19 January 2018

Our Ref VL/SPRUST(BROOKLANE).1
Your Ref A/11/17/OUT

Land South of A259 New Road and East of Brook Lane, Angmering, West Sussex --
Planning Application A/11/17/OUT

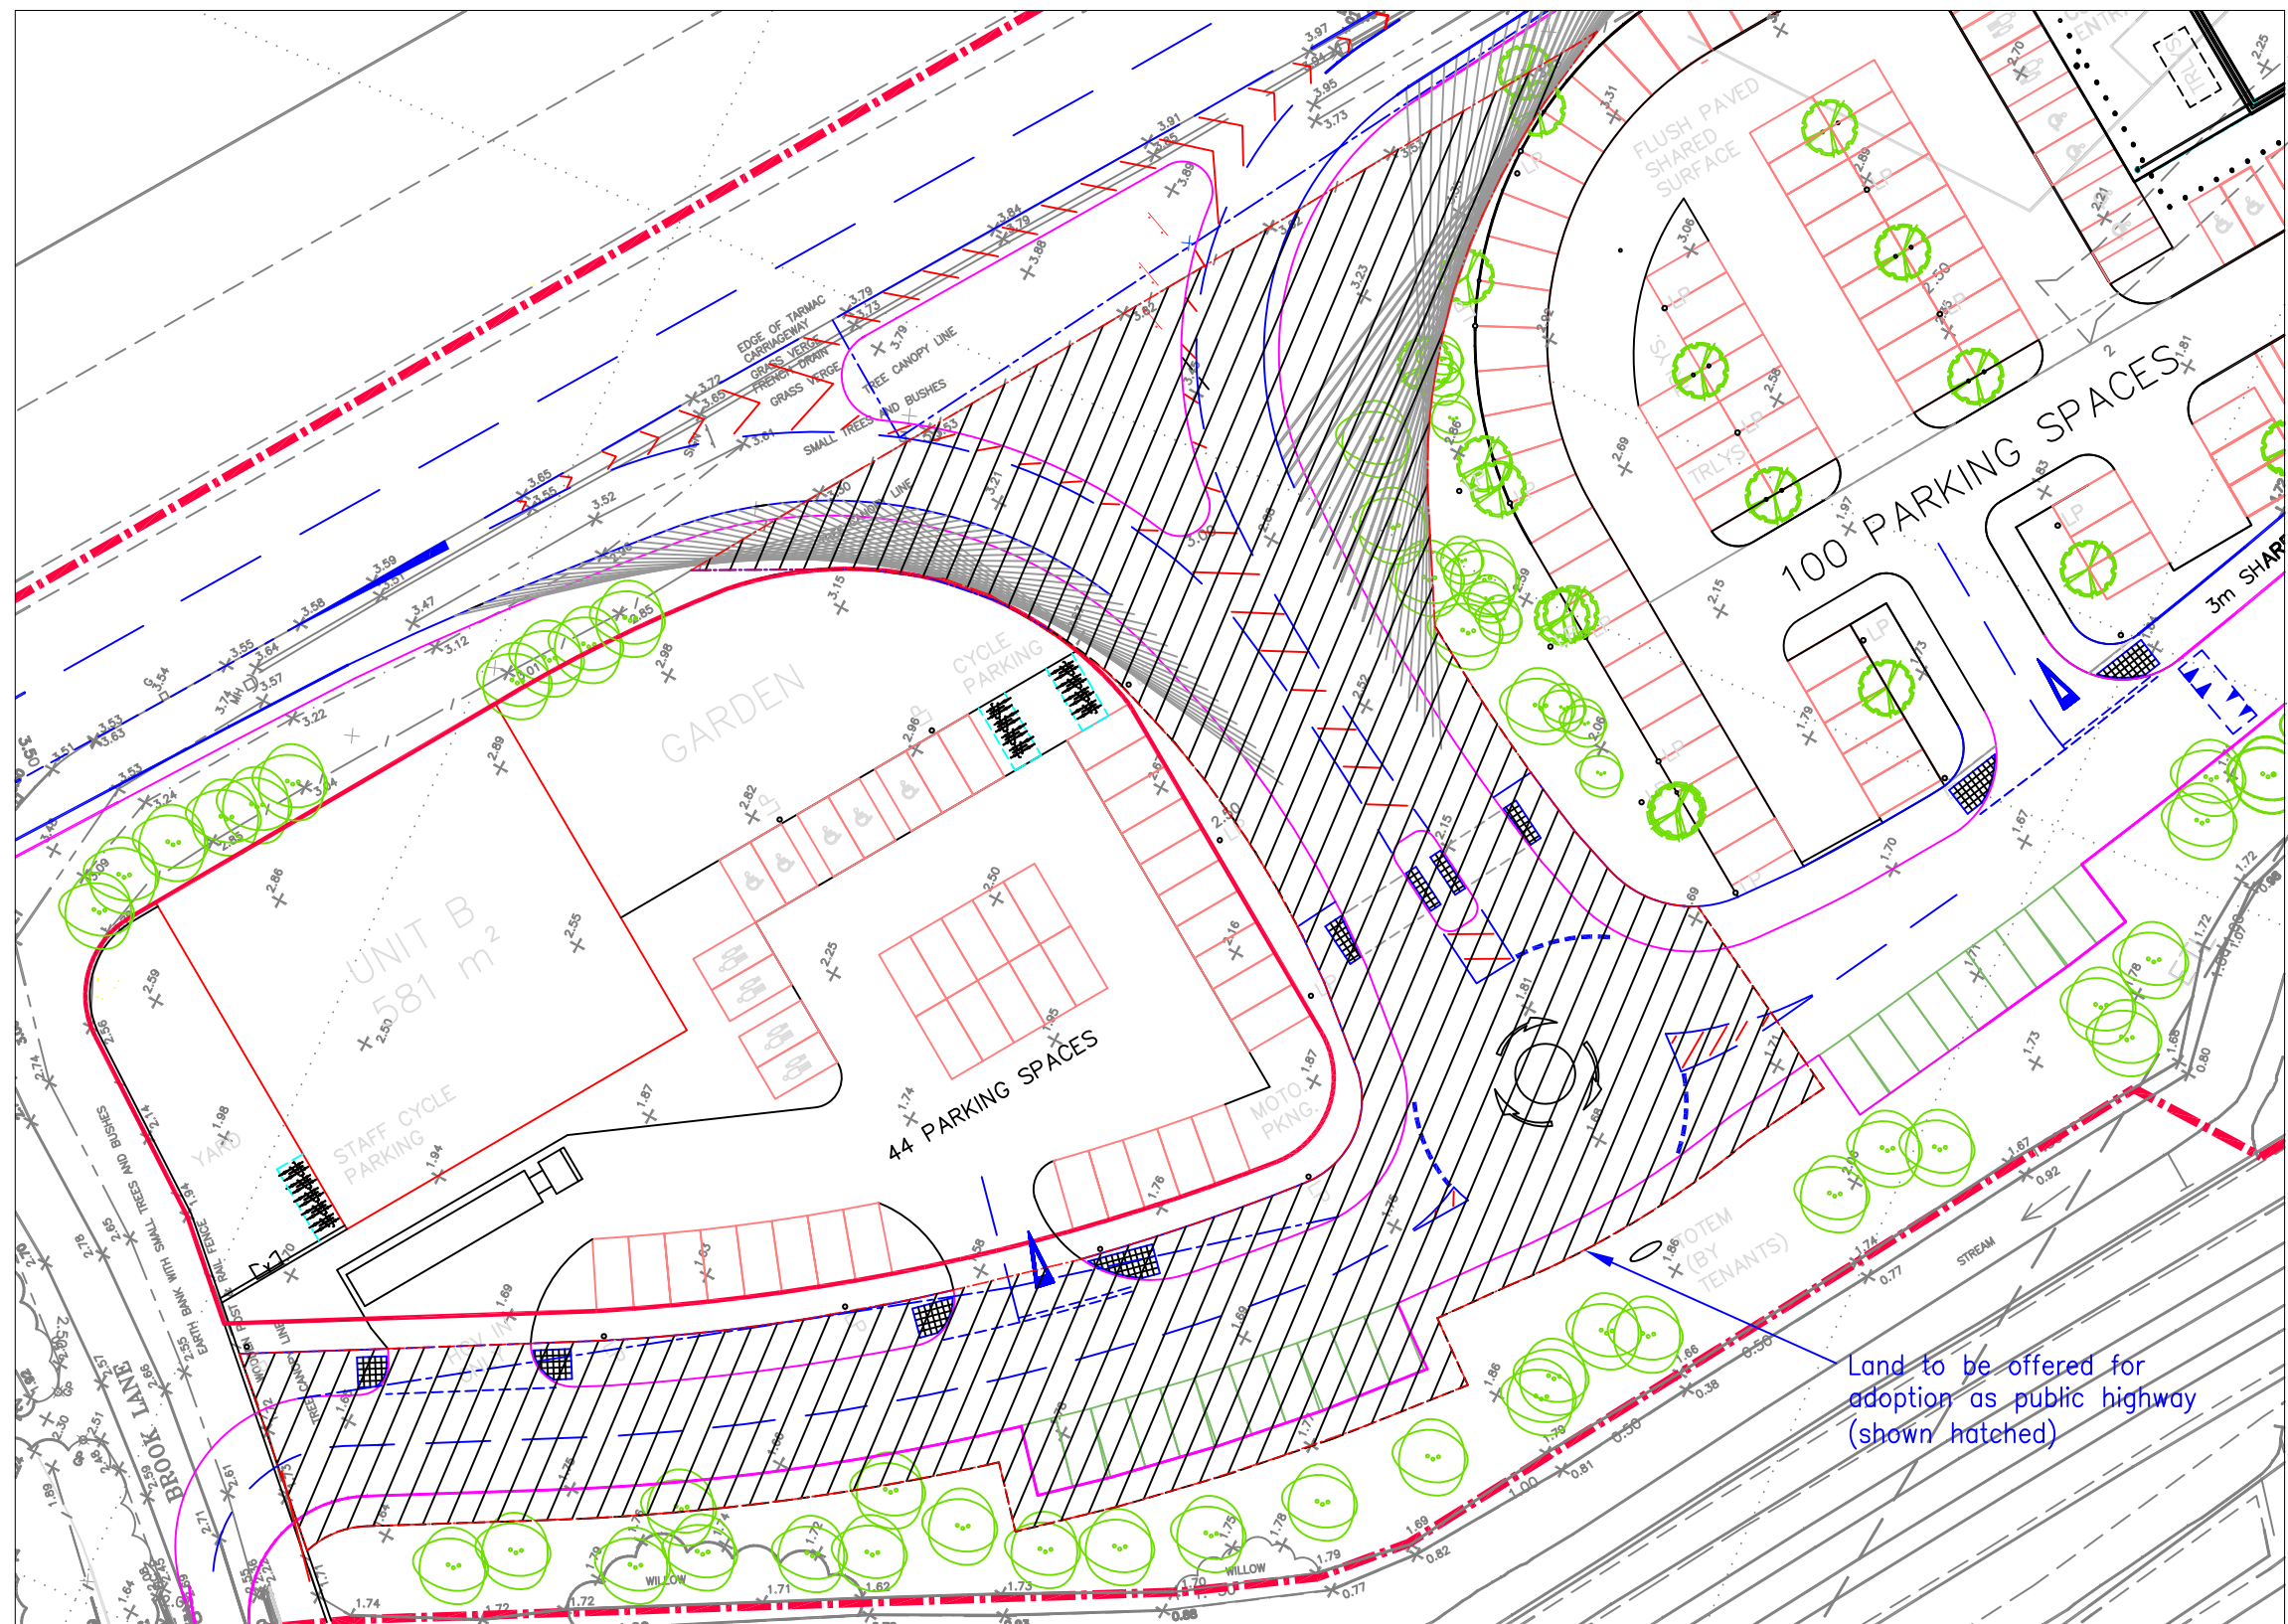
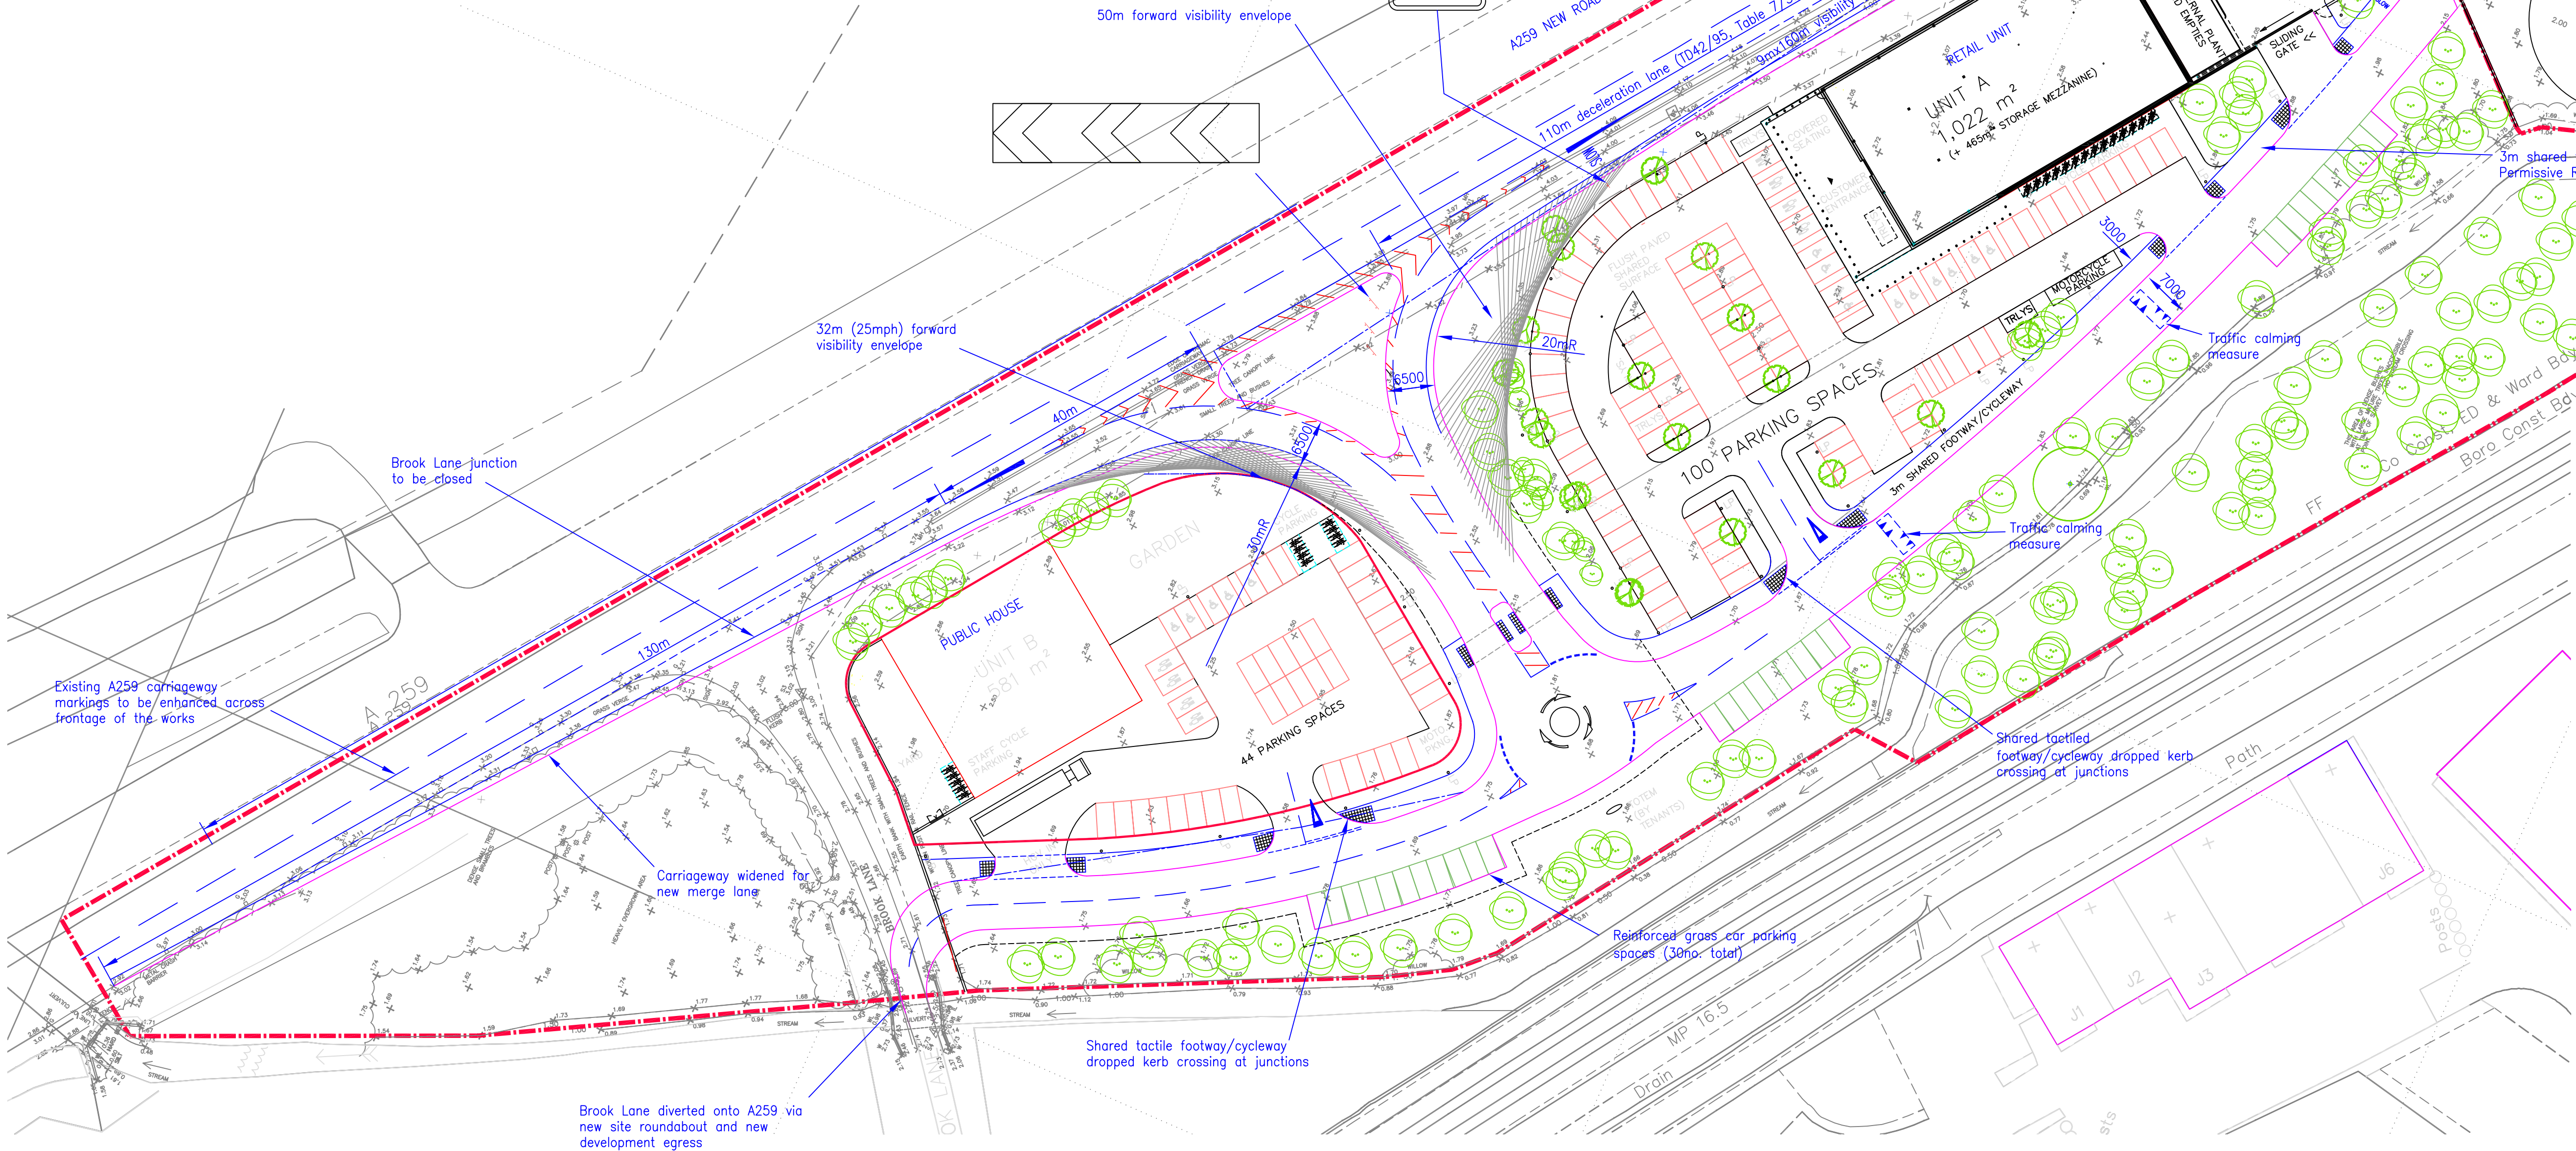
The proposed access arrangements for planning application A/11/17/OUT are shown on Redwood Partnership's drawing number REDW-3167-131 Rev B. It is intended that Brook Lane's direct access to the A259 would be closed and that Brook Lane would be diverted to pass south of the public house, through the mini-roundabout, to connect to the A259 via a new left-in/left-out access. In my letter of the 6th September 2017 I advised that the proposed diverted route of Brook Lane, through the mixed-use food store and pub development, is unsuitable as an access to the residential and care home development. The proposed alignment of the diverted route is contorted and narrows severely where it joins Brook Lane. Diverting Brook Lane, as proposed, would not provide a safe and suitable access. This is now a material consideration as the residential and care home development is a consented development.

The proposed access arrangements for planning application A/11/17/OUT would result in existing and future residents of Brook Lane having to pass through third party land to obtain access to the adopted highway, which is wholly unacceptable. The highway authority confirmed to the applicant on 19th July that the diverted route being proposed is not suitable for adoption. The applicant has proposed no alternative access arrangement in the six months since receiving
